Road Safety Audit Report

Incorporating
Stage 1 Completion of Preliminary design

The Old Dairy Littlehampton

CLIENT	Graham Nicolls Limited		
PROJECT	The Old Dairy, Little Hampton		
TITLE	Fire Tender accessing the site, turning and egressing		
DRAWN BY	GPW	CHECKED BY	GPW
DATE	16/12/13	DATE	4429/201
SCALE	1:250 @ A3	SCALE	4429/201
		SCALE	B

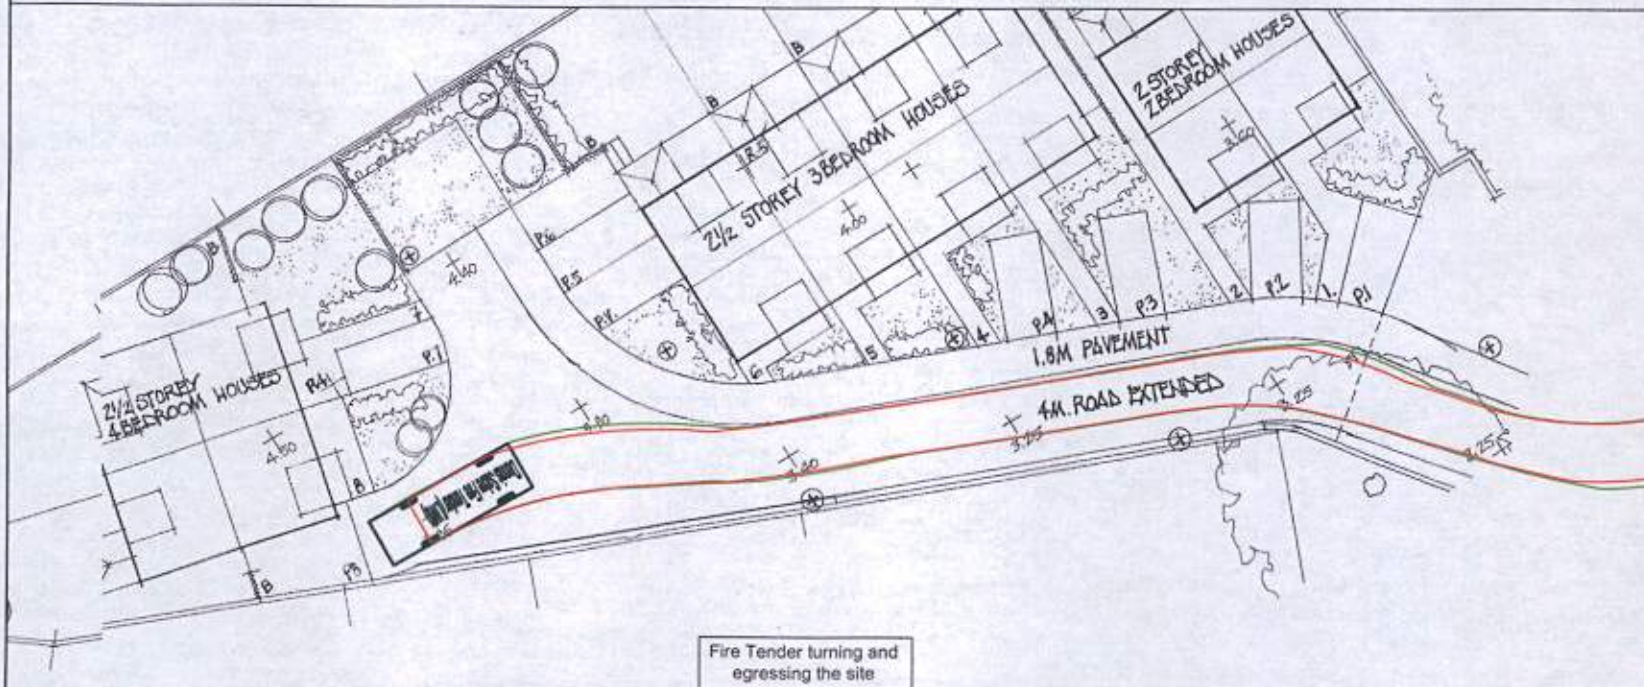
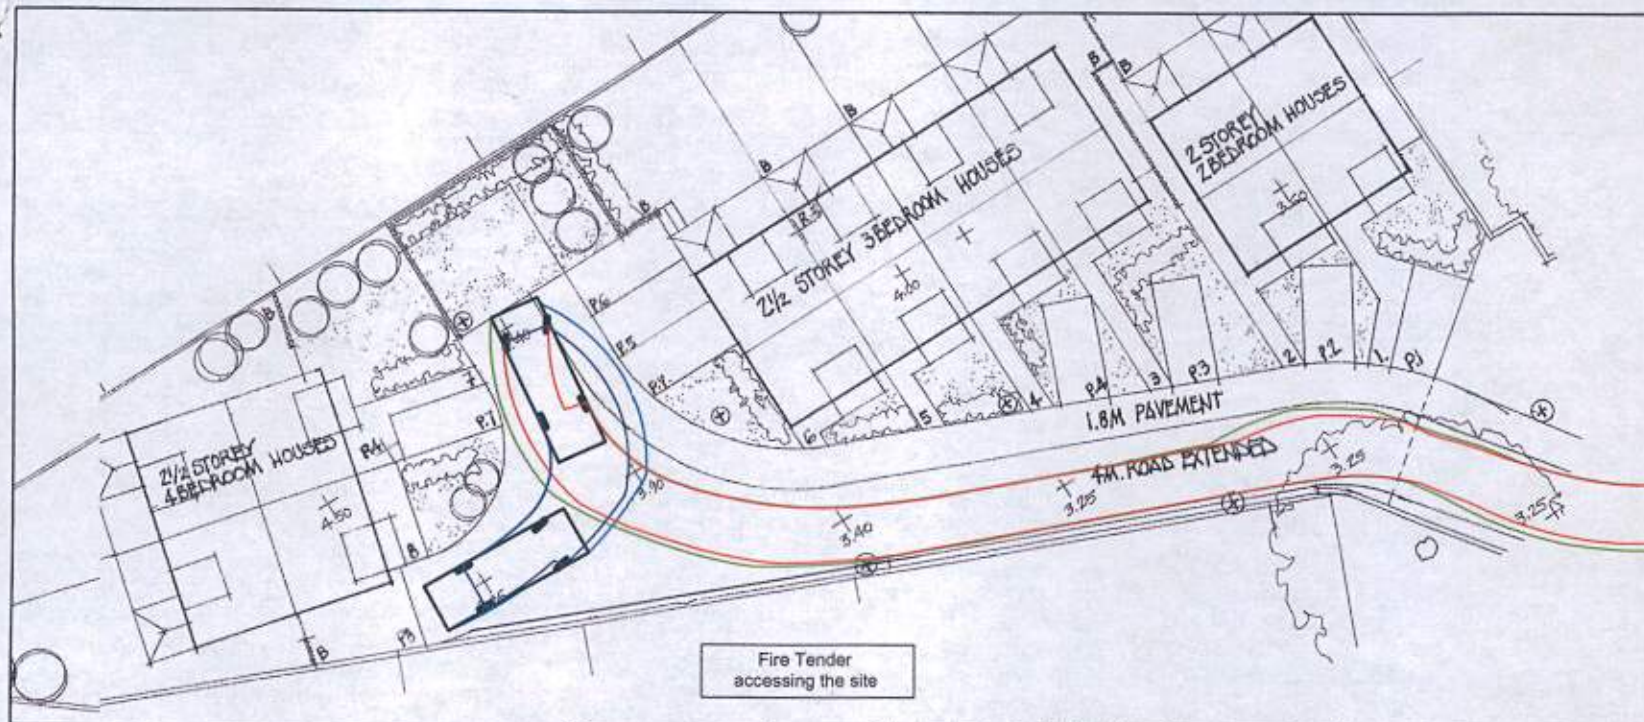
dlt n No.	Audit Team Observation	Audit Team Recommendation	Designer / Scheme Response
2	LOCAL ALIGNMENT		
.1	<i>The proposals do not have an impact on the alignment of Church Street and therefore no road safety concerns with regard to Local alignment have been raised at this stage.</i>		
3	JUNCTIONS		
.1	Problem <i>Restricted visibility</i> Accident Type <i>Vehicle Collisions</i> Location <i>Church Street west of the existing access</i> Although vehicles were observed to be travelling at low speeds in proximity of the access, visibility to the west is restricted by the adjacent boundary. Restricted visibility could lead to a vehicle egressing the site when it is not safe to do so.	A speed survey should be undertaken and visibility increased if necessary.	The alignment of Church Street to the west and the presence of the on-street parking bays adjacent to the site result in vehicles not travelling along the channel line and therefore visibility is sufficient, ref: paragraphs 10.6.1 and 10.6.2 of Manual for Streets II.
